Rezoning Transportation Analysis

Petition Number: 2023-034

Revision Log:

Date	Description
06-28-23	First Review (TM)
07-28-23	Second Review (TM)

RZ 1.0

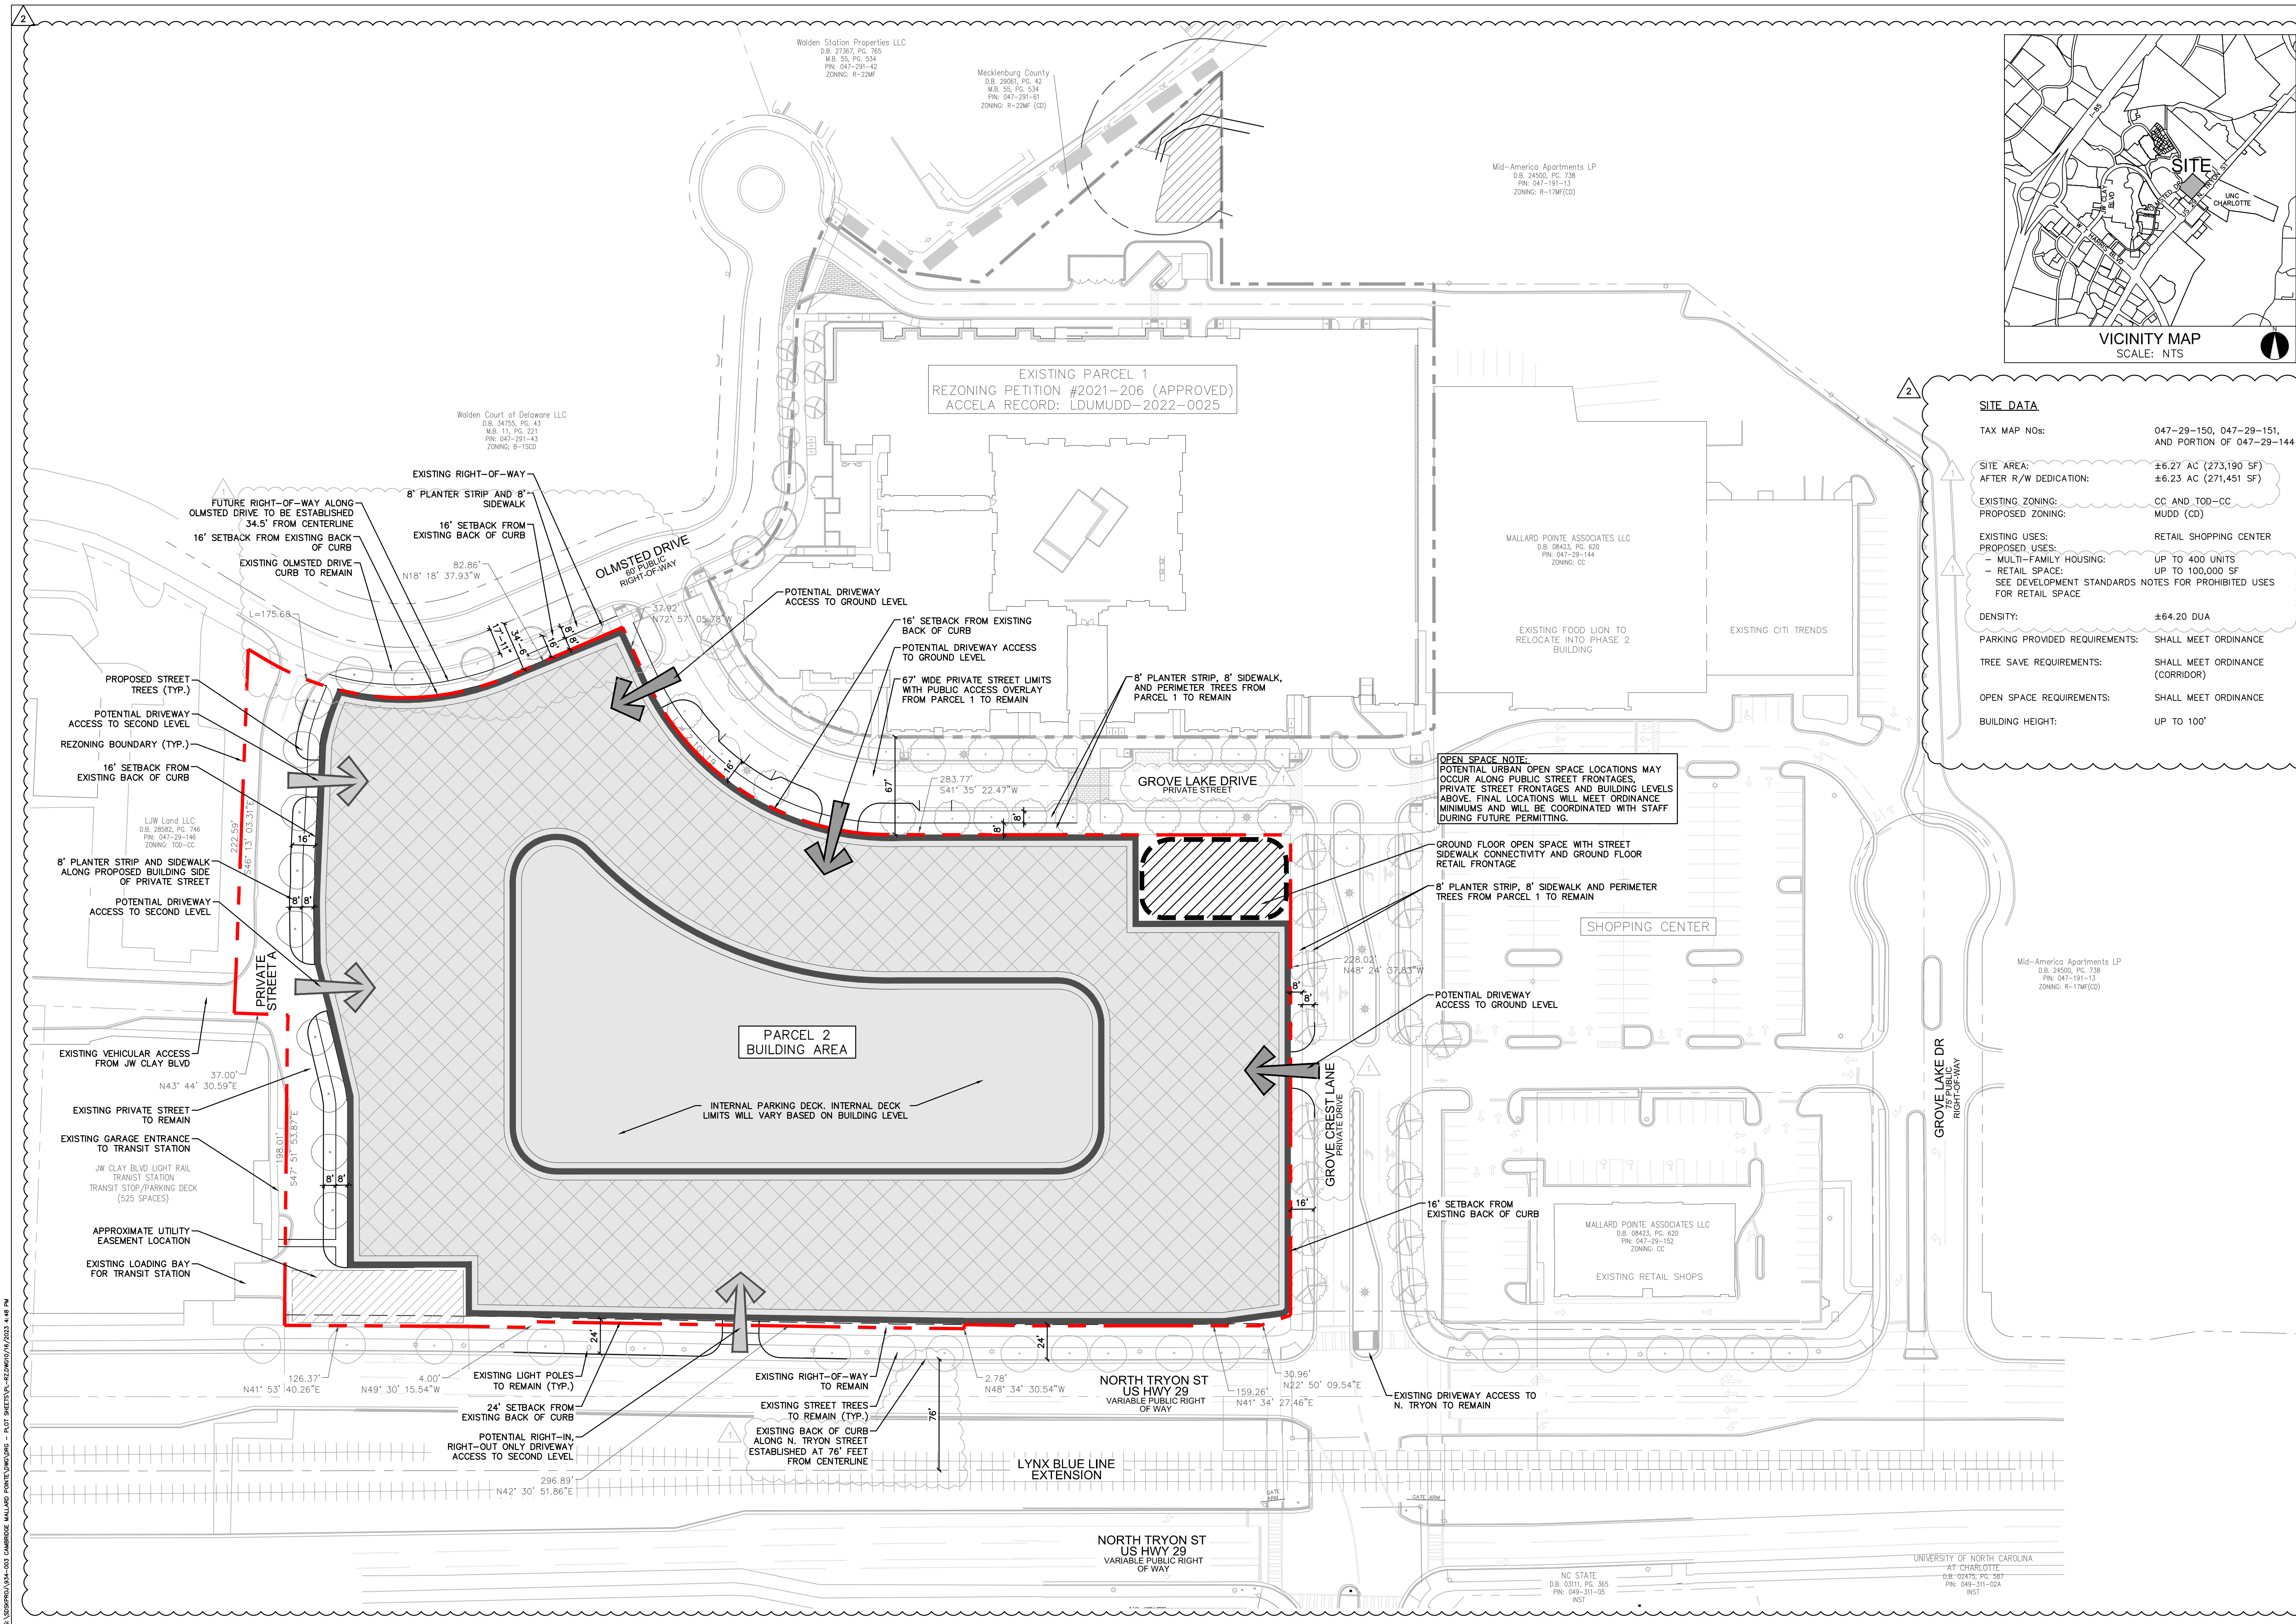
2. **Traffic Study:**

A Traffic Impact Study is required for the complete review of this petition due to the site generating more than 2,500 daily trips and/or triggering other City TIS requirements.

7. Request: Revise site plan and conditional note(s) to commit to extending the 8-foot sidewalk on Olmsted Drive to J W Clay Boulevard CIP project.
8. Add a conditional note specifying "the Petitioner shall dedicate and convey in fee simple all rights-of-way to the City before the site's first building certificate of occupancy is issued. CDOT requests rights-of-way set at 2' behind back of sidewalk where feasible."
